RFI

RFI #: 135
 Date: 5/31/2012
 Job: EB-02 Keller Springs Lofts
 Phone: 877-777-5115

Subject: Slab at Club Poured Short

ID.4.3

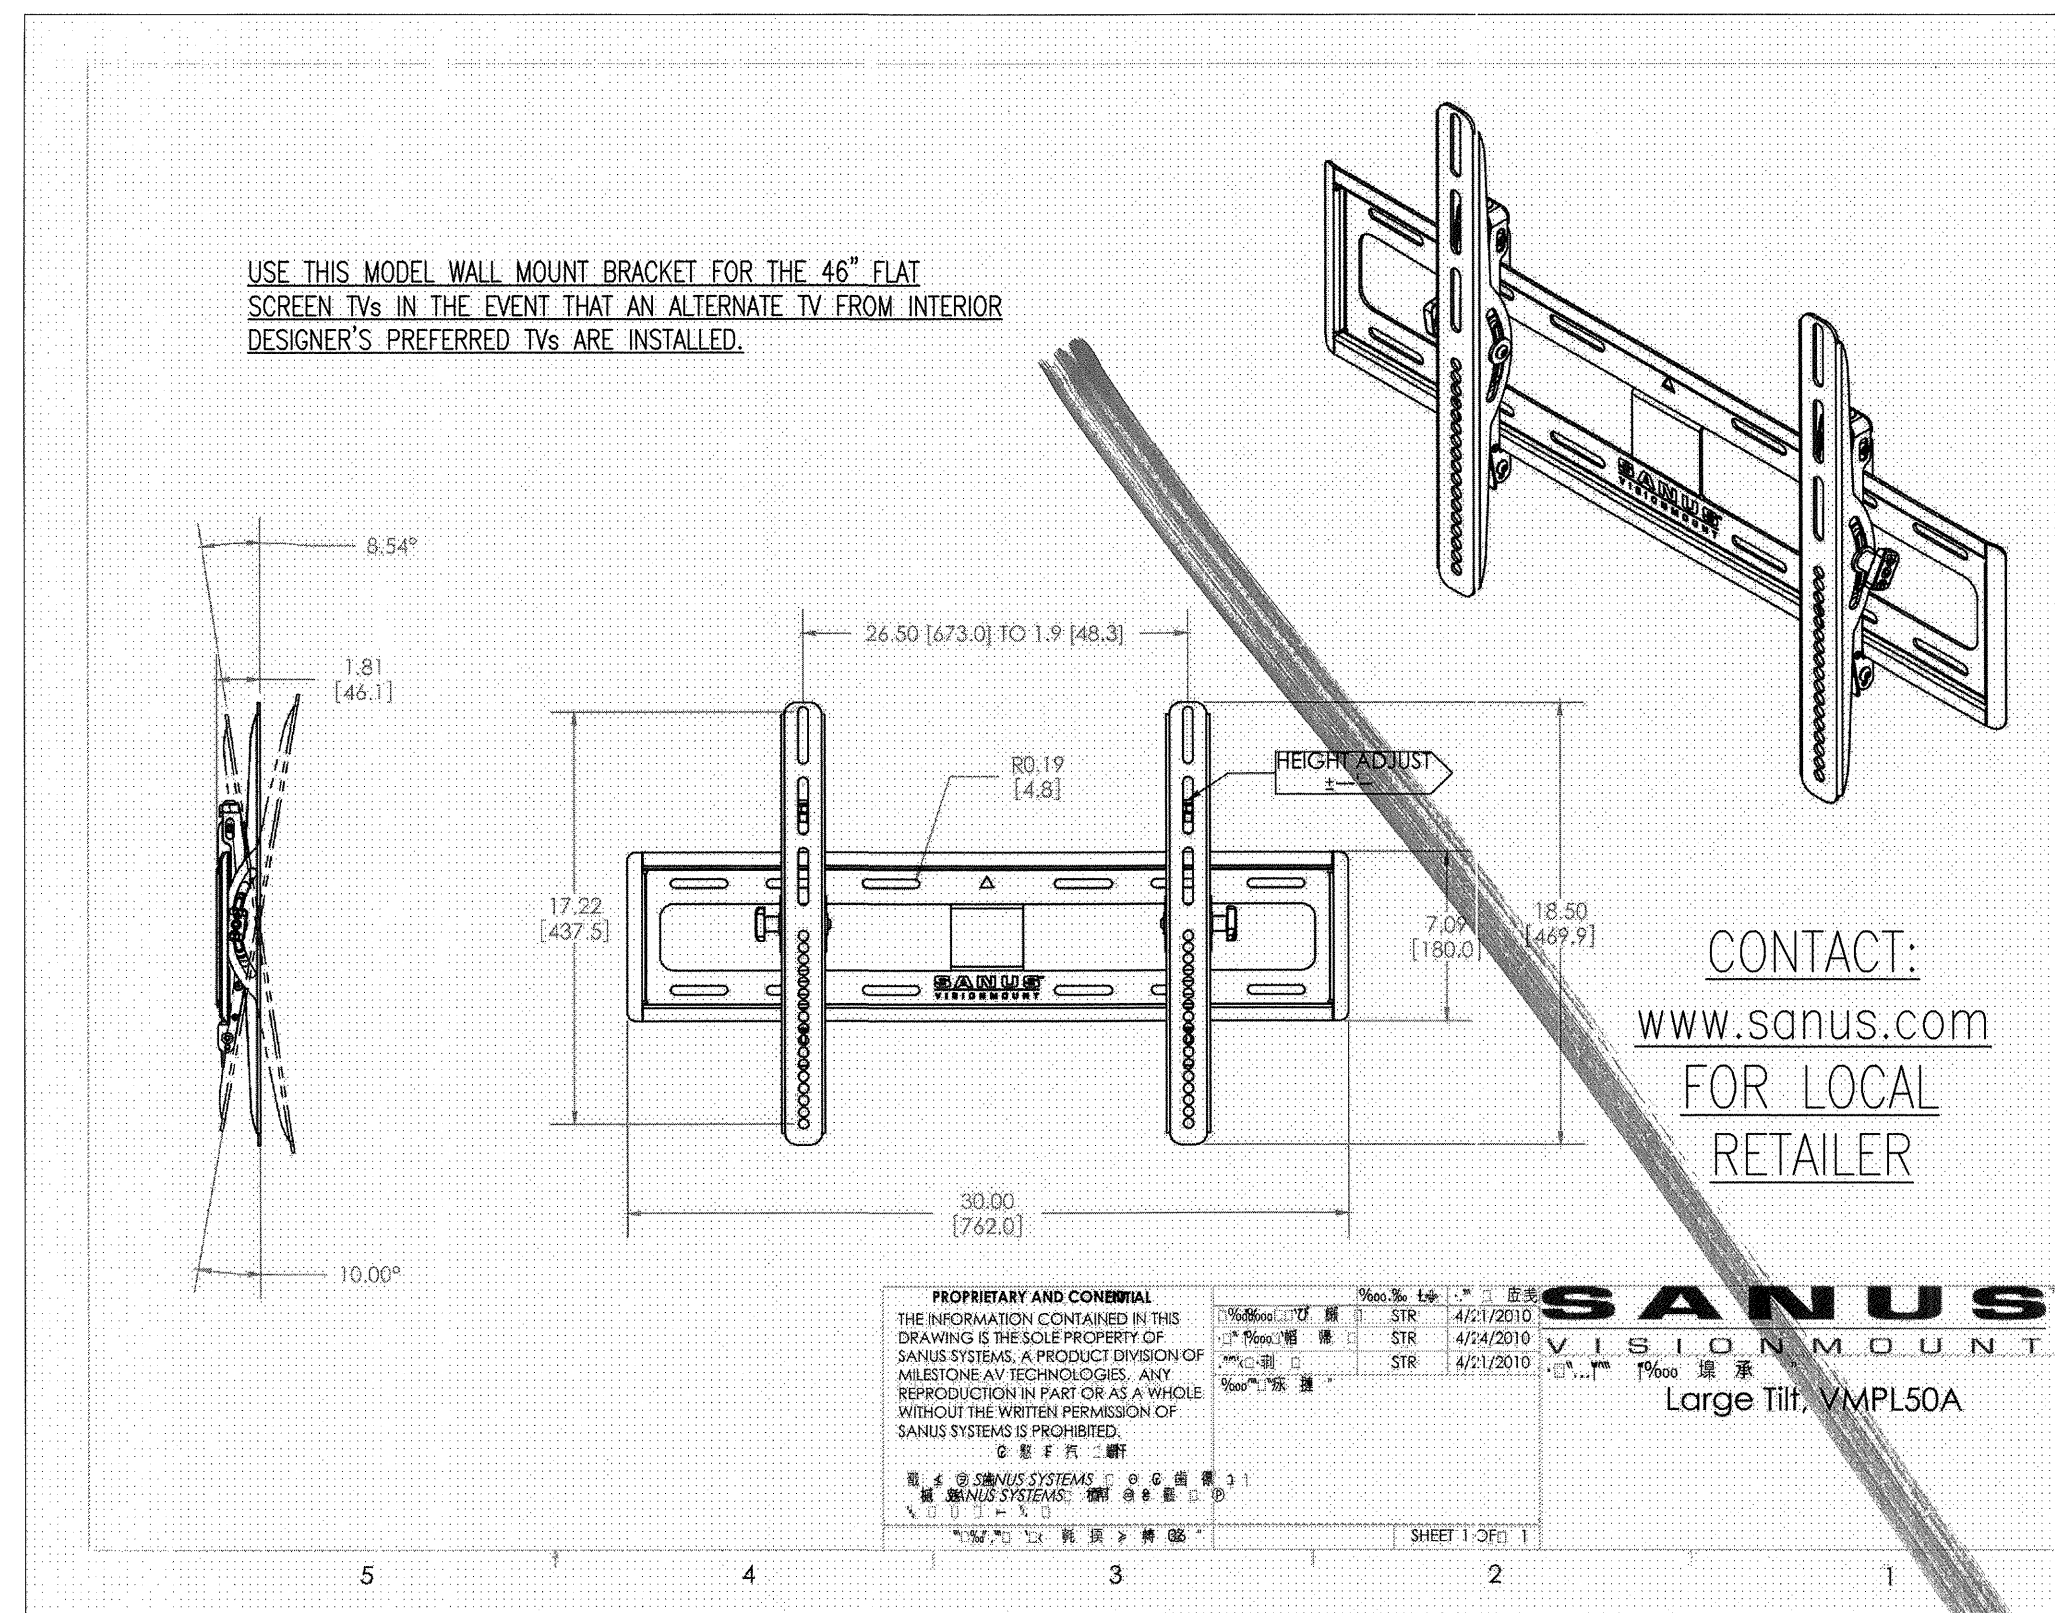
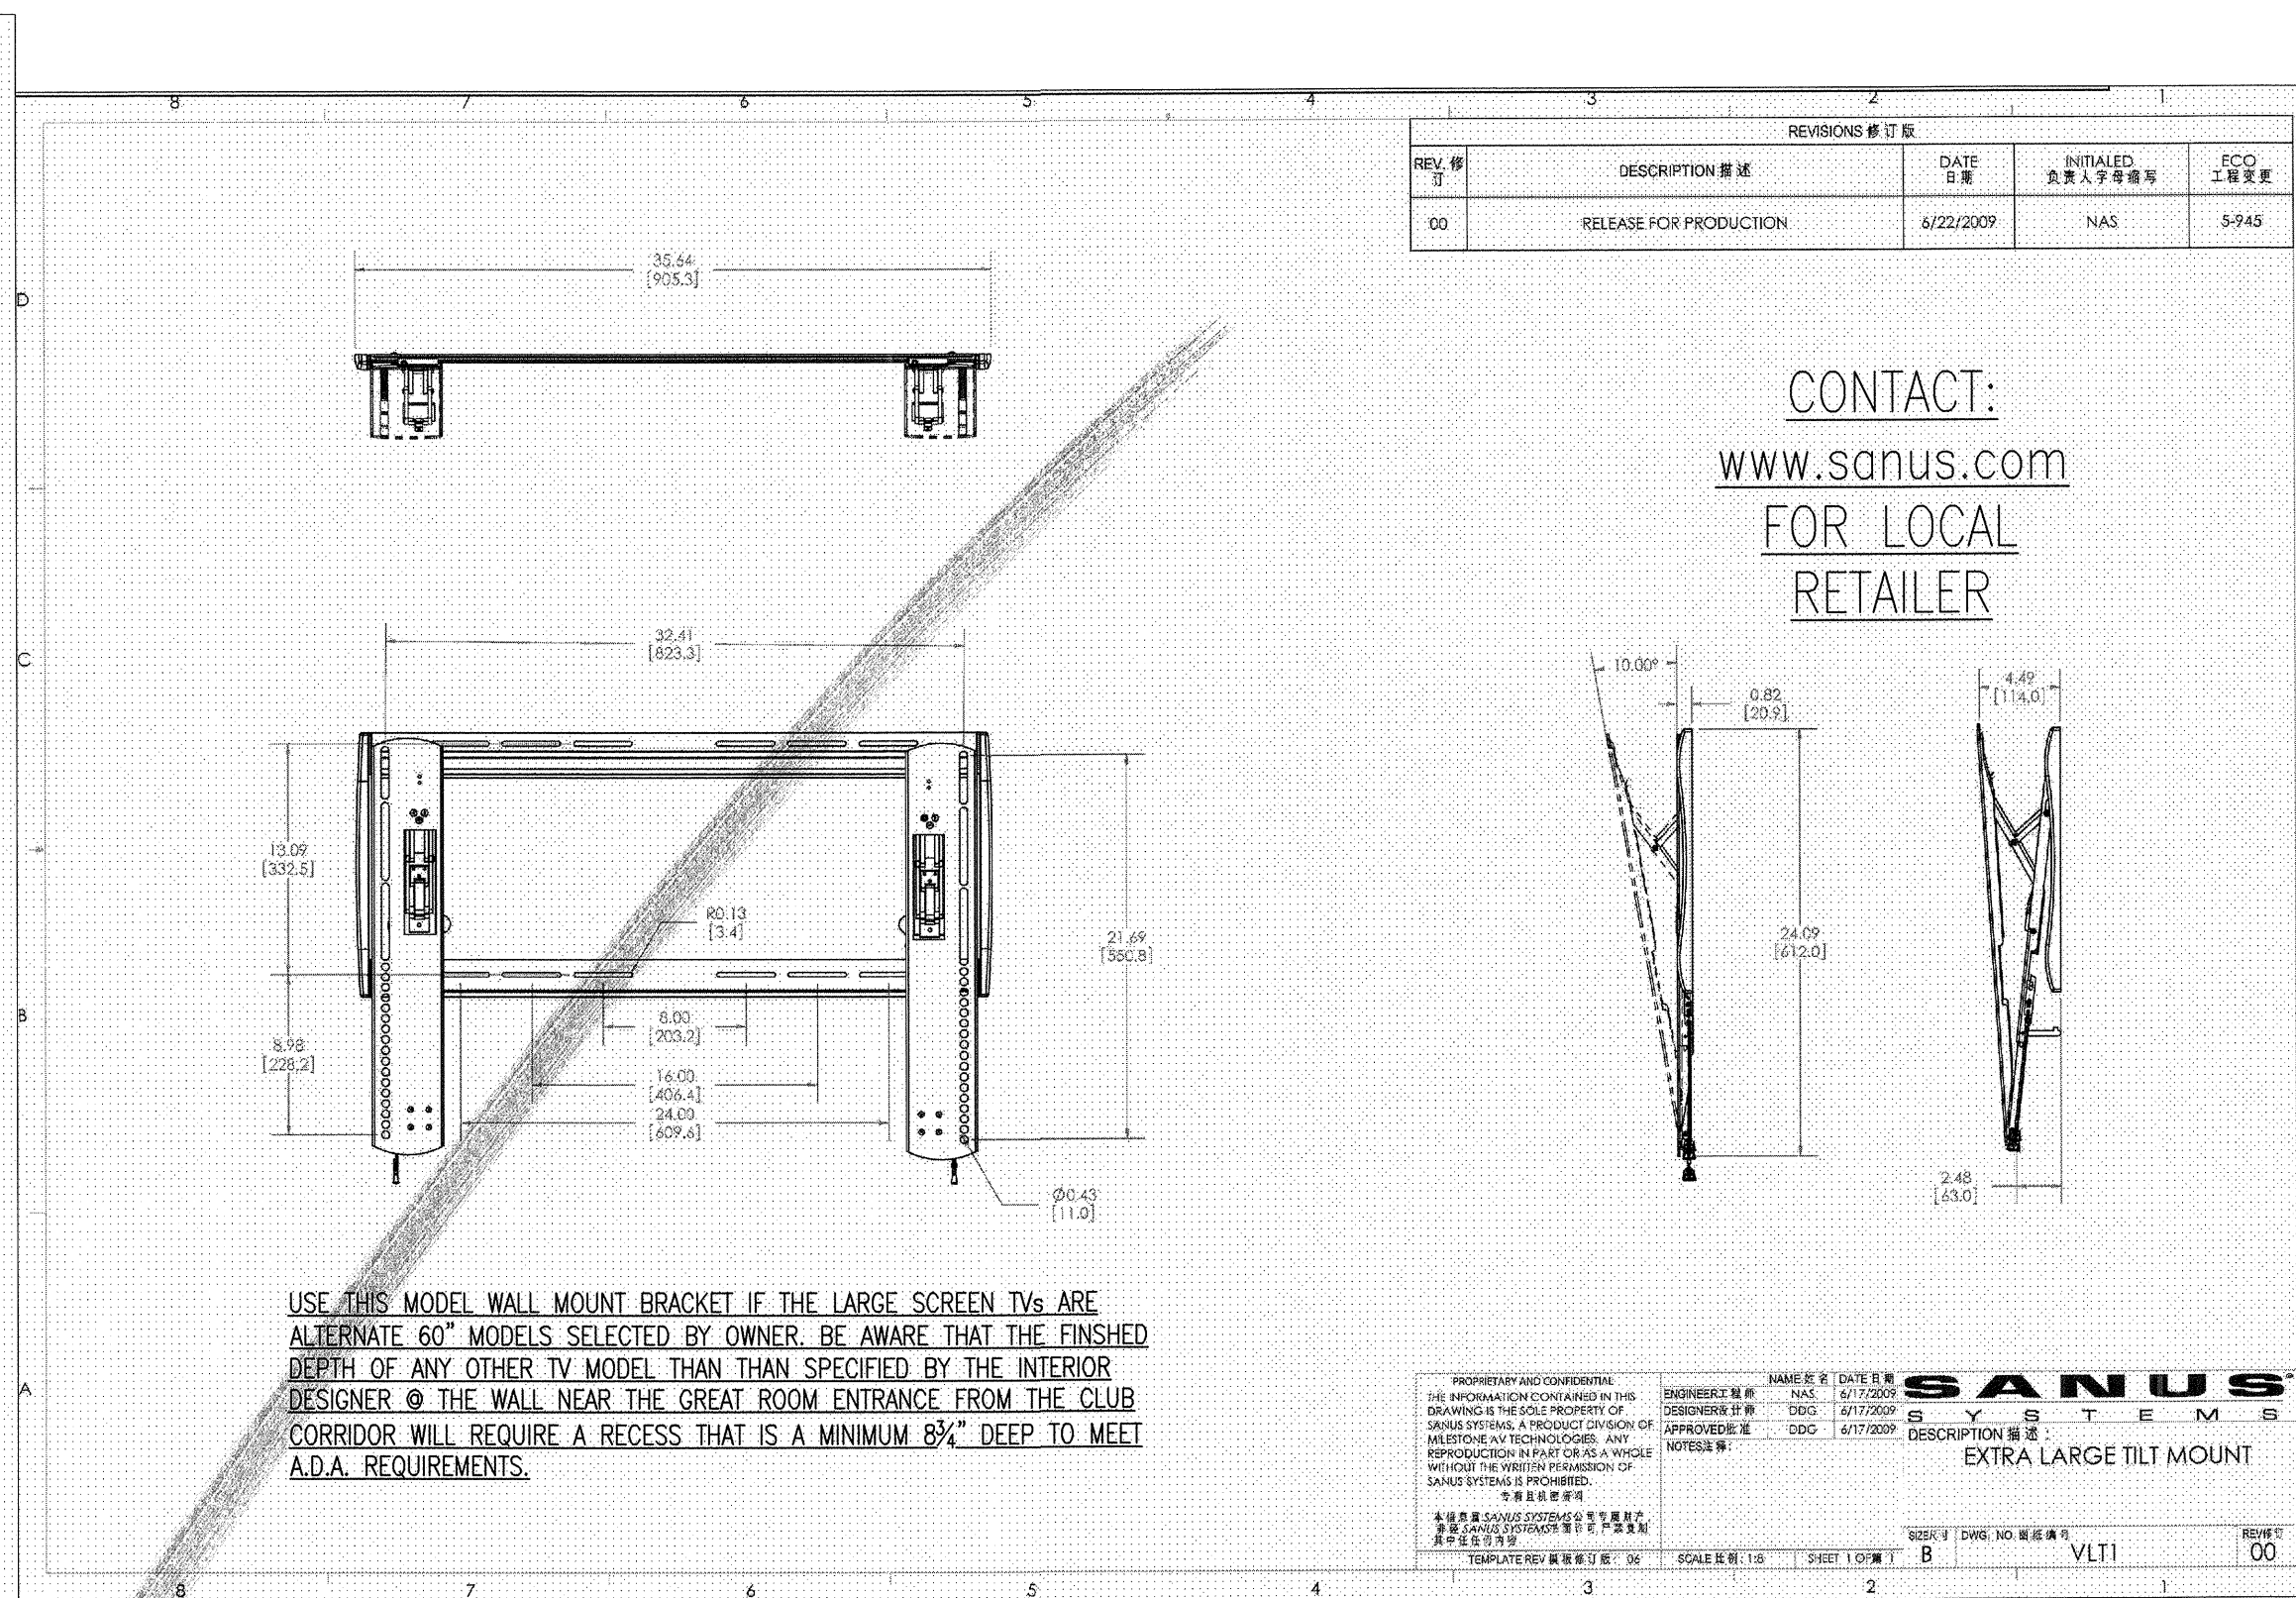
Subject: Great Room TV / Proper Rating for Wall

Drawing: A9.1, 4/ID7.0 & 3/ID7.2
 Cost Impact: None
 Spec Section:
 Schedule Impact: None

Request:
 Please confirm that we have the rating we need for the 2 HR separation wall as it is drawn by in Interior Designer. Please see the attached drawings.

Response:
 There are two stud walls in this area, and working with Les Wagoner (Embrey), we have coordinated that the 2hr UL wall assembly will go on the unit side stud wall in this area to allow for ID's detail to not affect the 2hr assembly. Les has confirmed that the 2hr assembly will be continuous around the club no matter which direction the 2hr wall turns.
